Report of the Head of Development Management and Building Control Committee Report Part 2 – Application Report

79116/APP/2024/2794

Site Address: **38 Varcoe Gardens, Hayes**

Proposal: **Conversion of integral garage to habitable accommodation with alterations to fenestration.**

DRAWING TITLE
Proposed Front & Rear Elevations

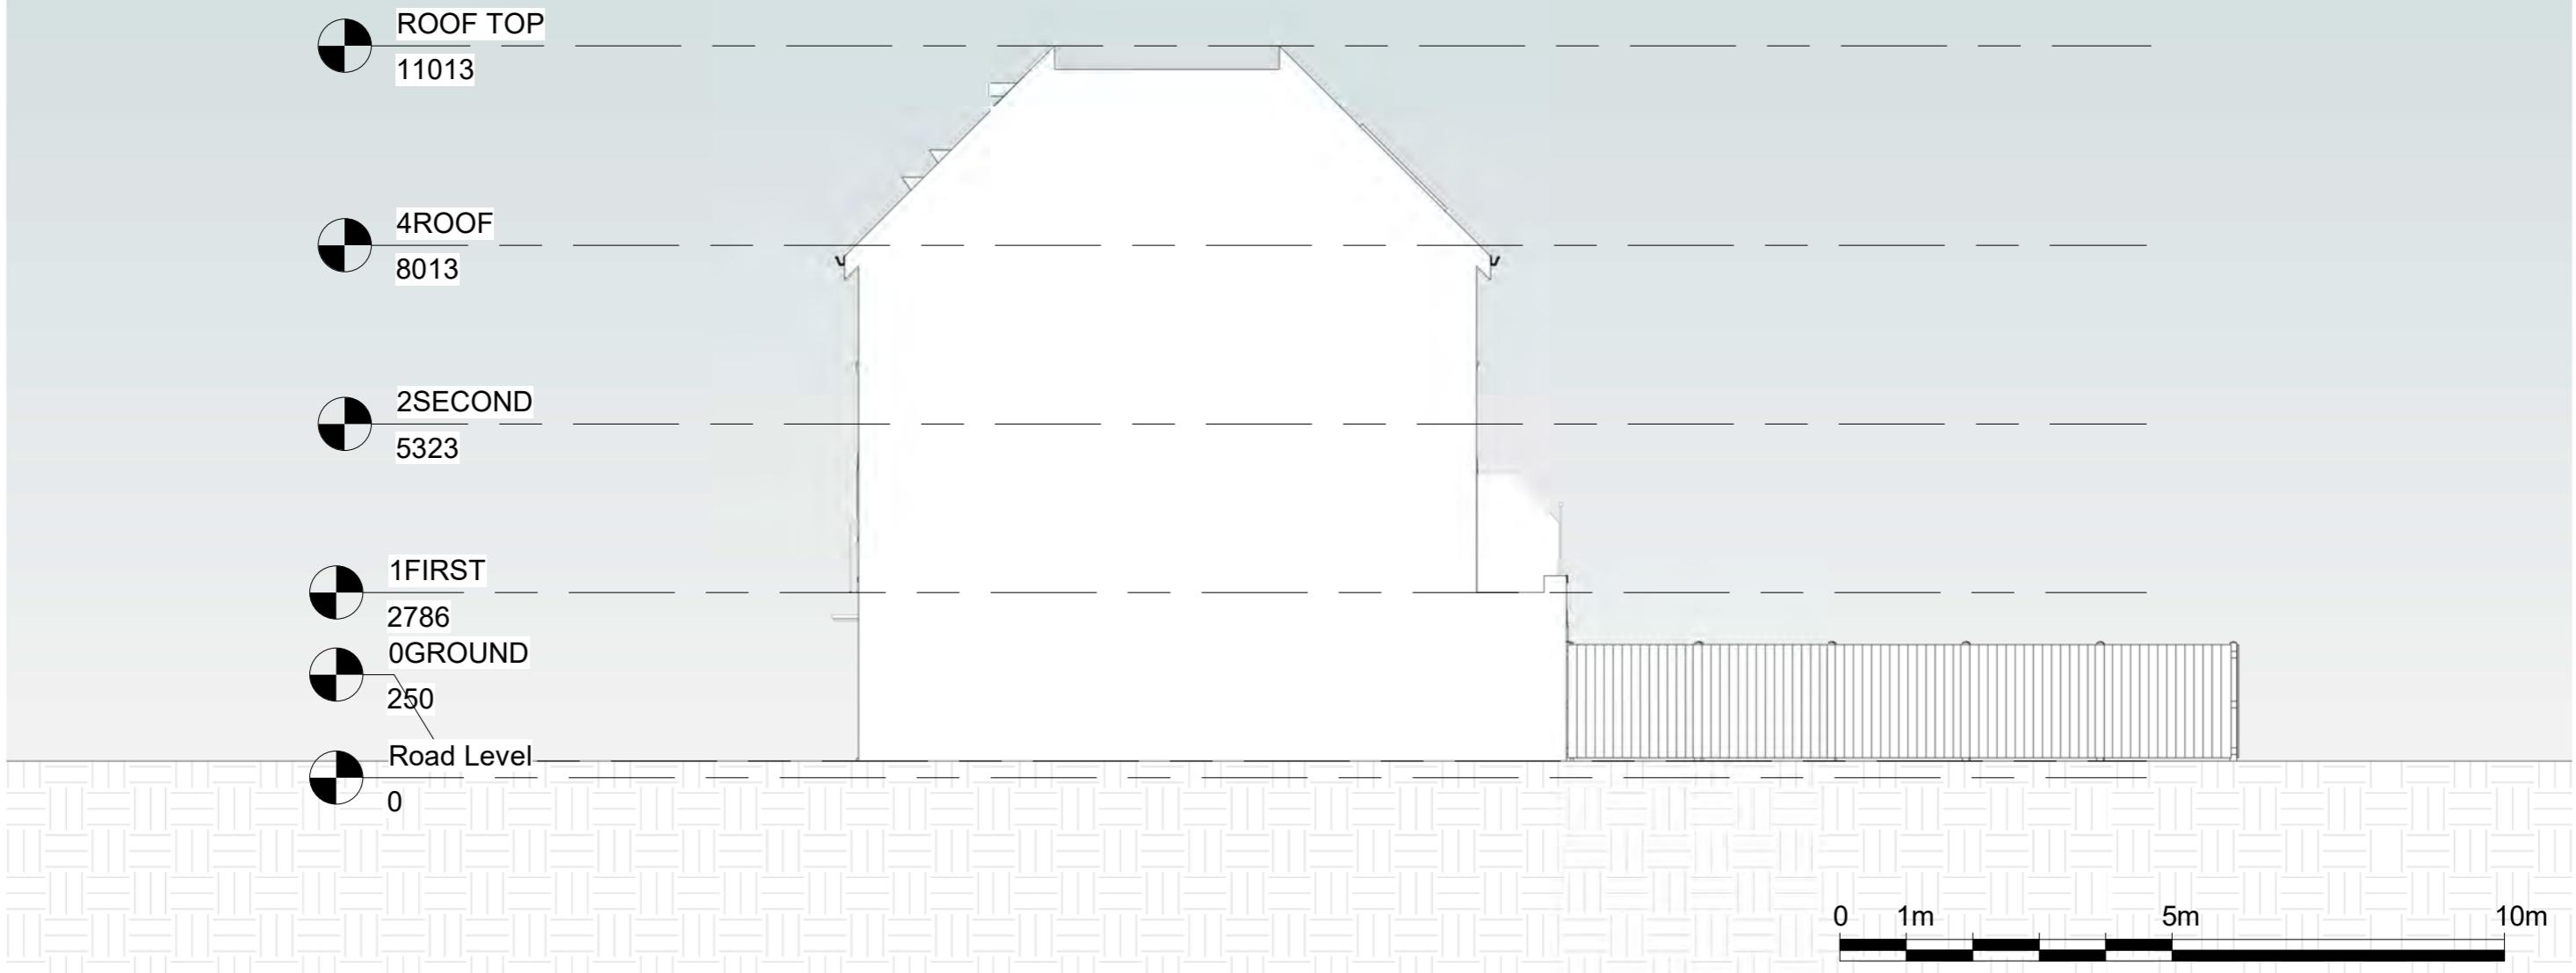
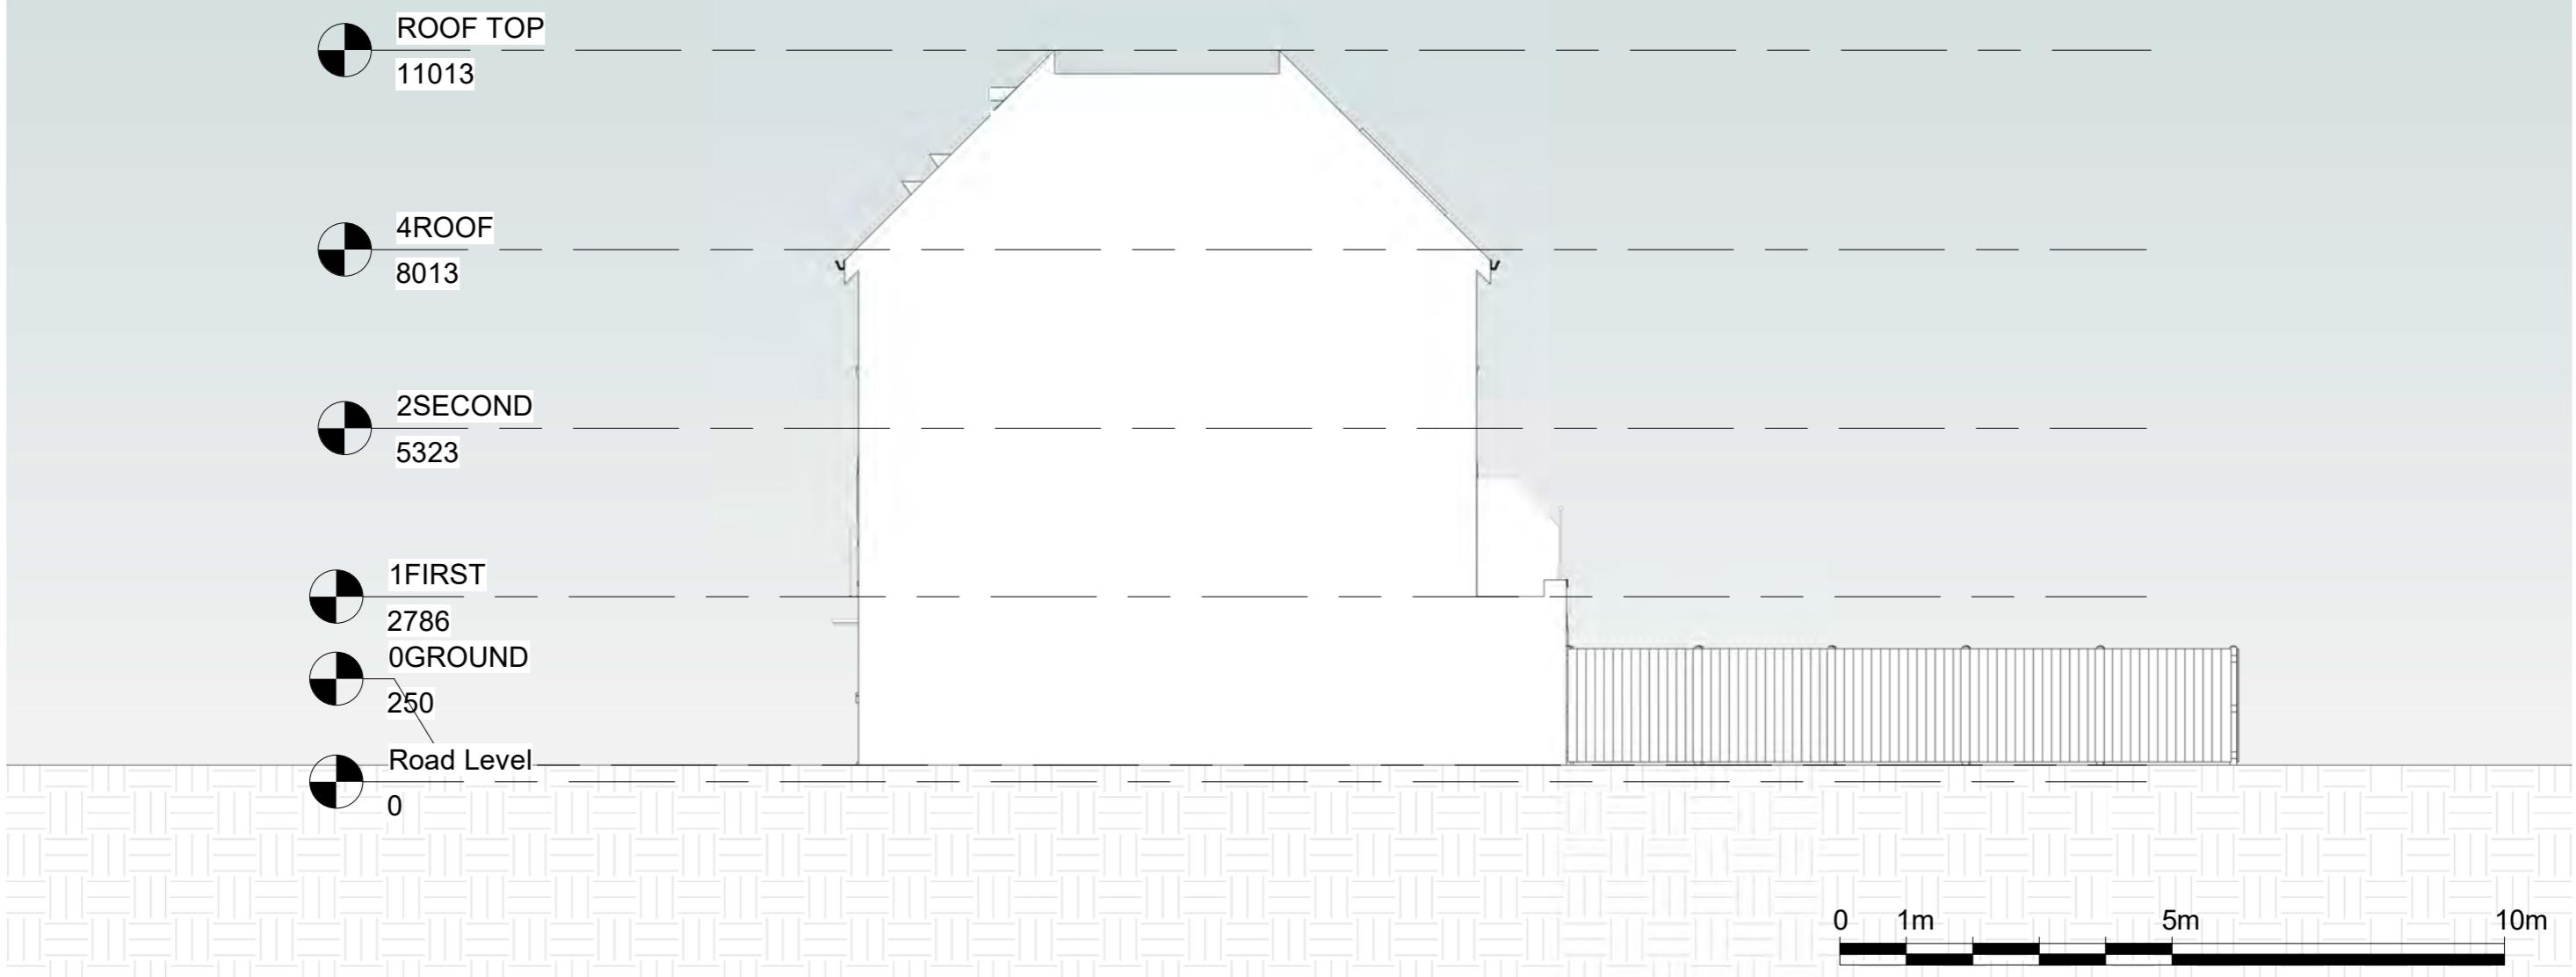
7.6 The proposed conversion of the integral garage to habitable accommodation would involve replacing the existing garage door on the front elevation with a window of a similar style to the existing windows on the property to facilitate the use of the room as a step-free additional living space.

7.7 There is one other garage conversions within the Estate at no. 85. The Estate itself is very uniform in its design with all the three storey terraced dwellings including an integral garage at ground floor. This being the case the proposal would cause some visual harm to the uniformity of the area, however given that

no.85 has benefited from conversion, officers do not see a reason to warrant refusal due to its modest and architecturally sympathetic design.

7.8 The applicant has advised that there is a need for an additional living space on ground floor level at the property on medical grounds. However, the proposals are considered to be acceptable, as set out in this report, independently of that assertion. A condition will be added to ensure that the building materials and windows match the existing property.

3. HO4 Materials

The materials to be used in the construction of the external surfaces of the development hereby permitted shall match those used in the existing building and shall thereafter be retained as such.

Proposed ground floor

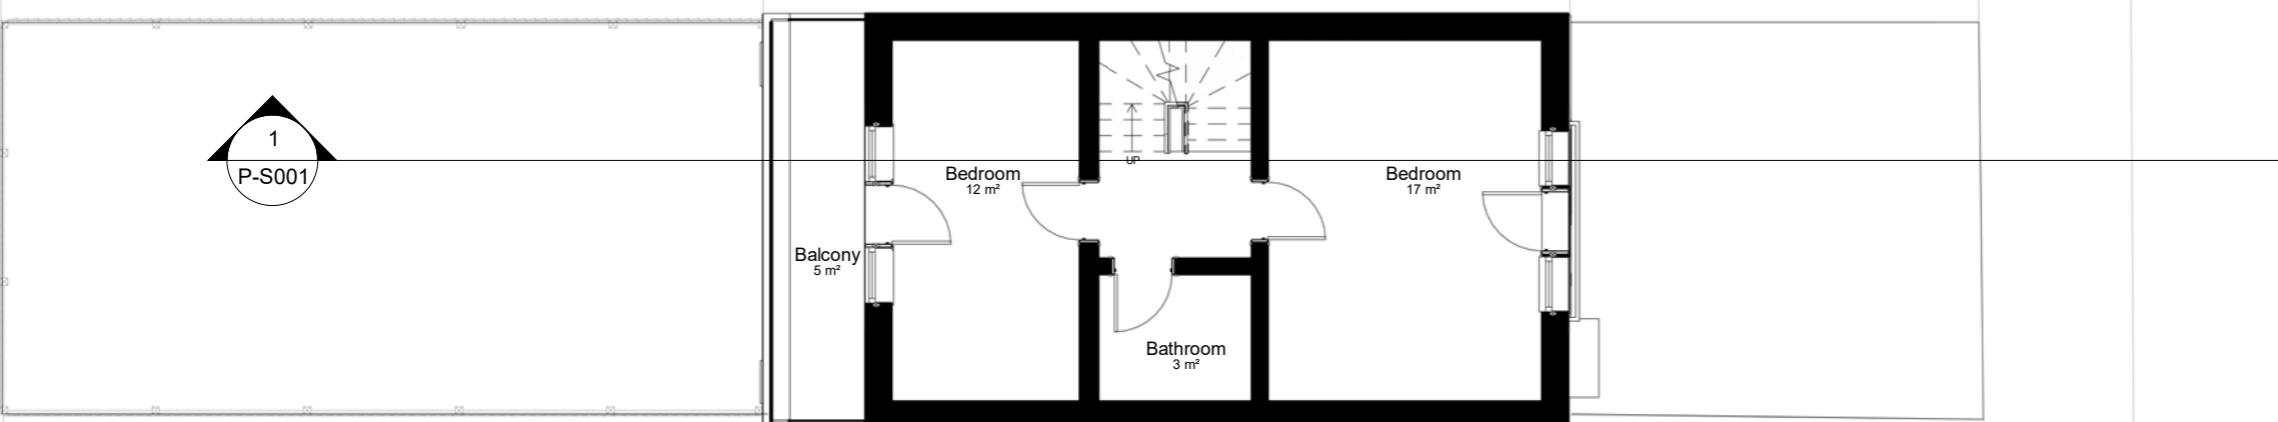
7.1 There would be no harm to the amenities of the neighbouring properties as no overlooking would be created, and as no additional floorspace is created, there would be no loss of light, loss of outlook, nor would it be overbearing. The host would still retain their parking space to the front of the property, therefore no additional parking strain would be created.
